Submission for Job: #2770 Site 4 - Commercial Retail Residential redevelopment
https://majorprojects.onhiive.com/index.pl?action=view_job&id=2770

21 December 2010

Re: Major Project MP08_0244 Environmental Assessment (EA) for Construction of a Mixed Use Commercial, Retail and Residential Development at 23-37 Lindfield Avenue and 11 Havilah Avenue, Lindfield

1 JUNE 21 -9AM
1:500

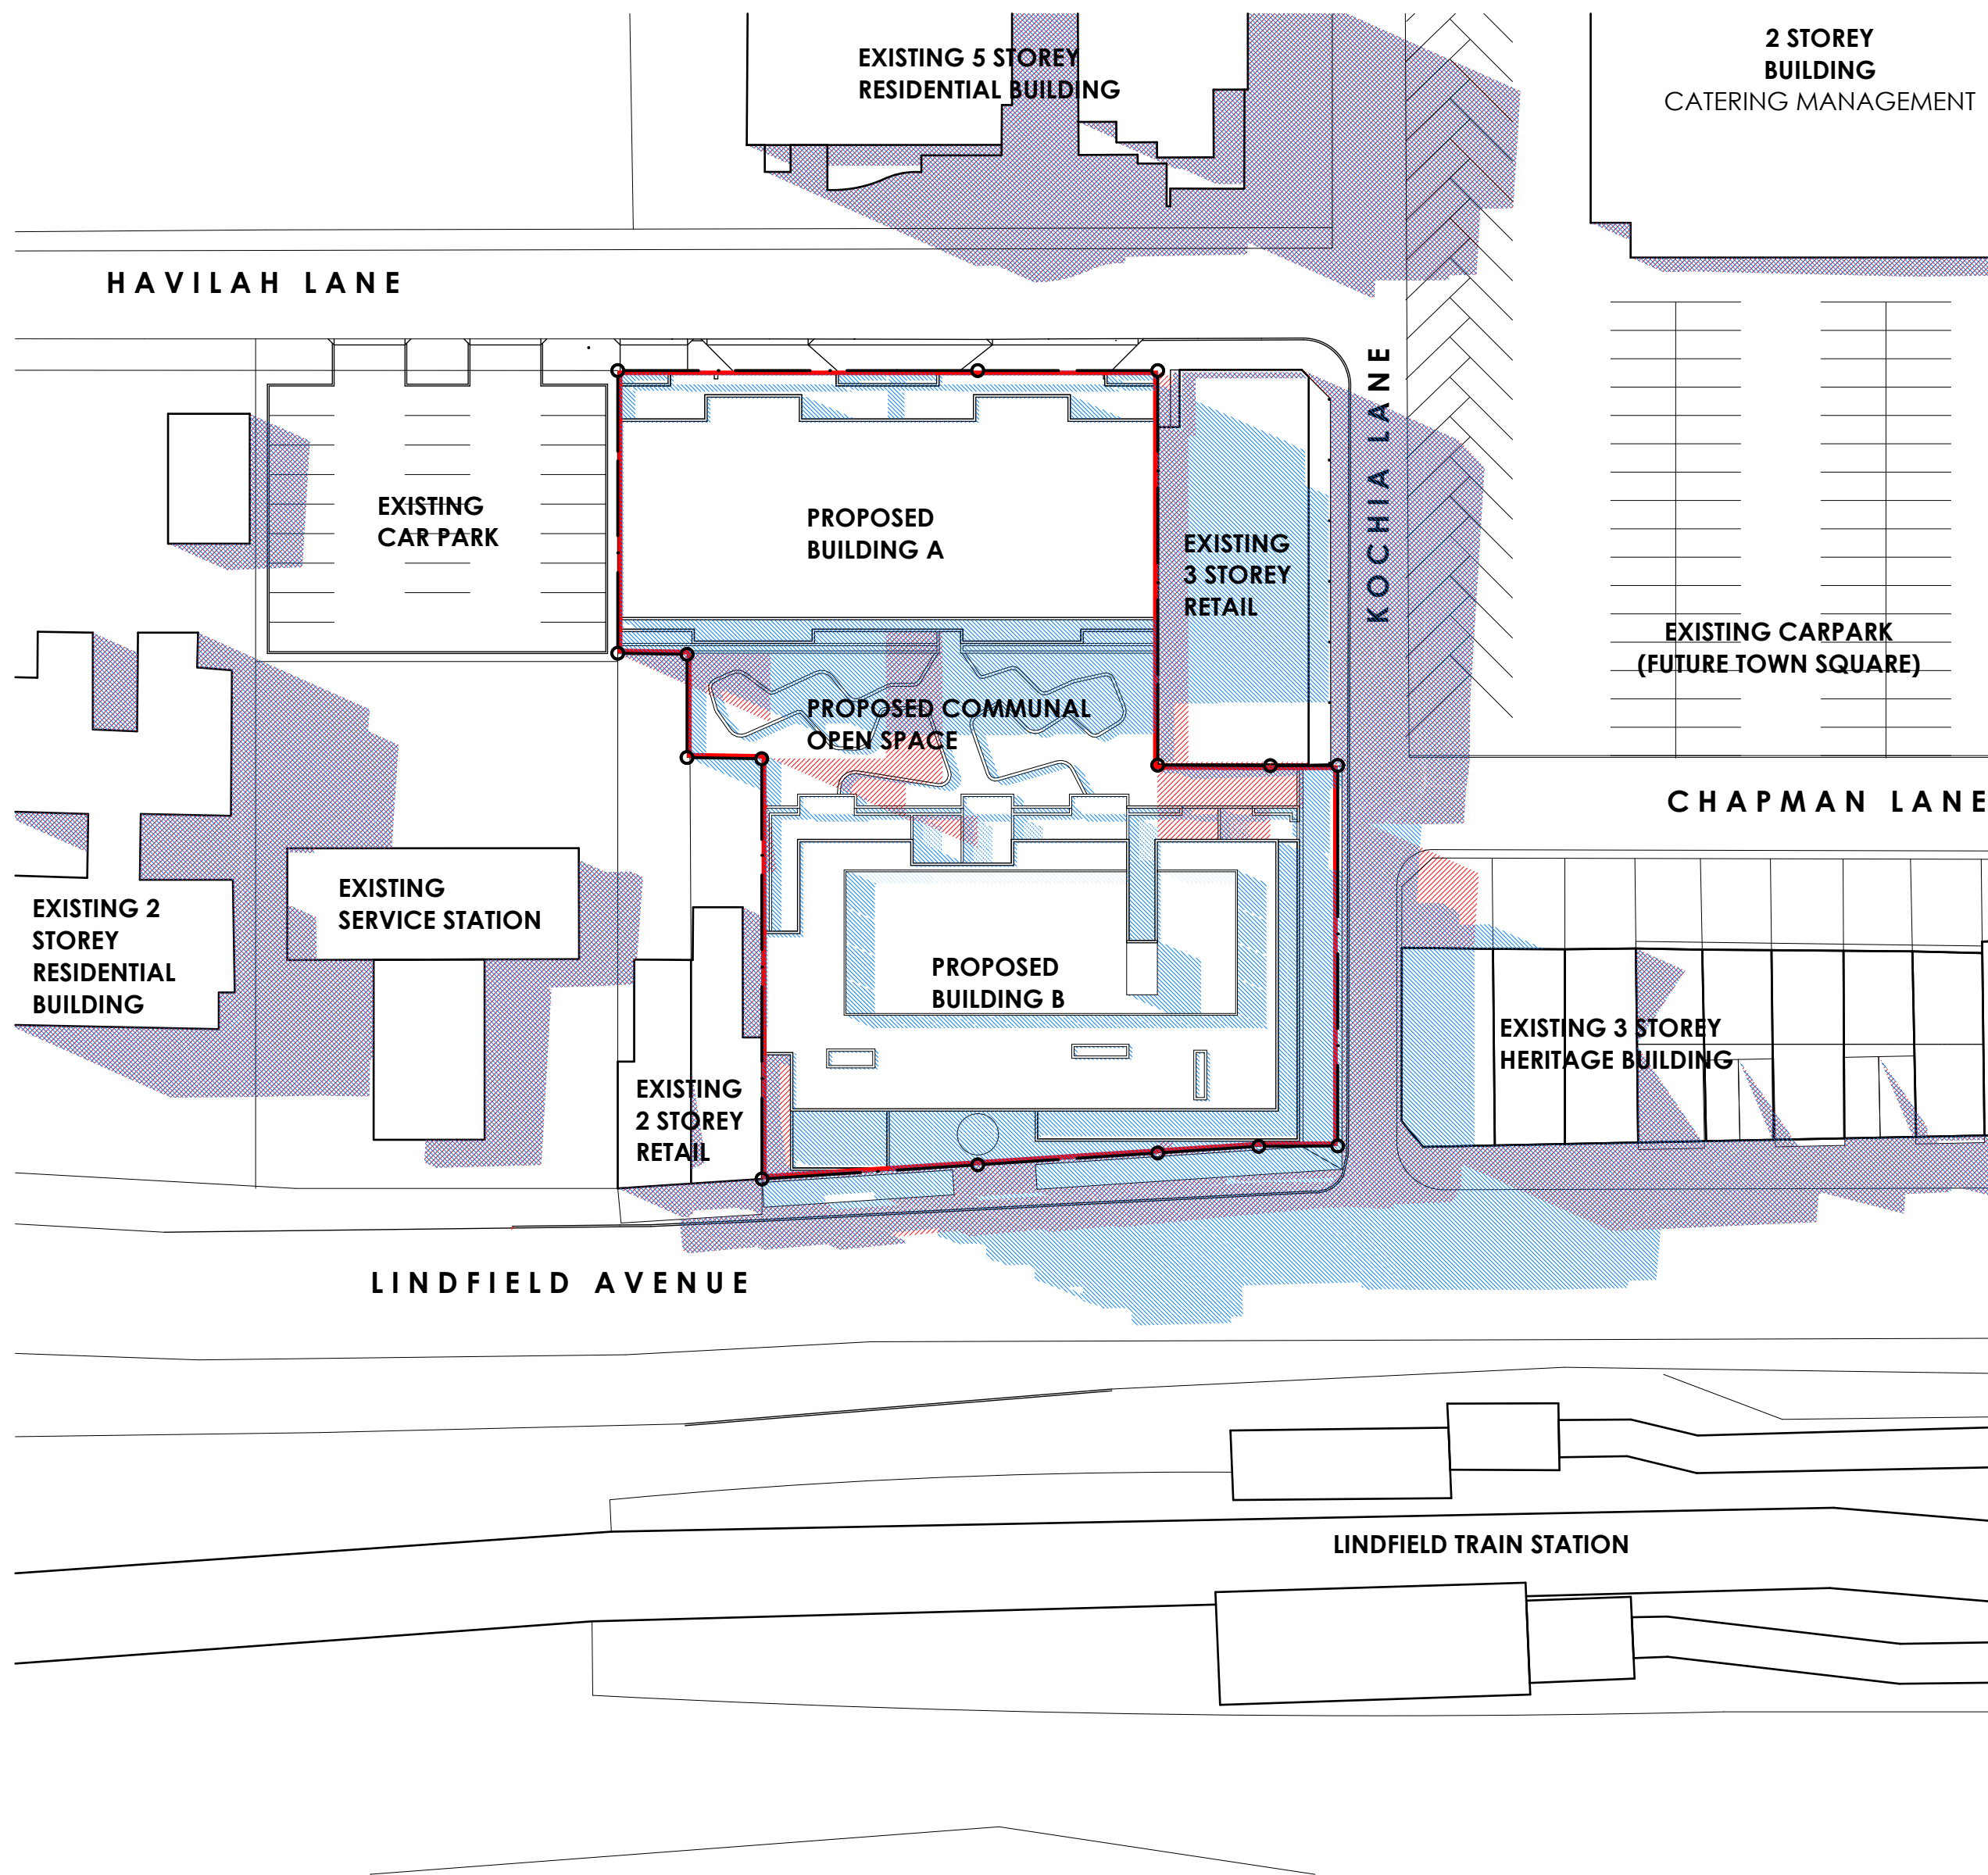
- The Lindfield Avenue building at 7 storeys will cast **significant shadow on the railway station (which is an open station)**, affecting a larger number of commuters as per the March, June and September Shadow Diagrams.

- The development will cast significant shadows on future open space in the proposed town centre, causing loss of amenity to the broader community, as per the June and September Shadow Diagrams.

b) Maintain development to a maximum of 5 storeys, in line with the broader Lindfield environment.
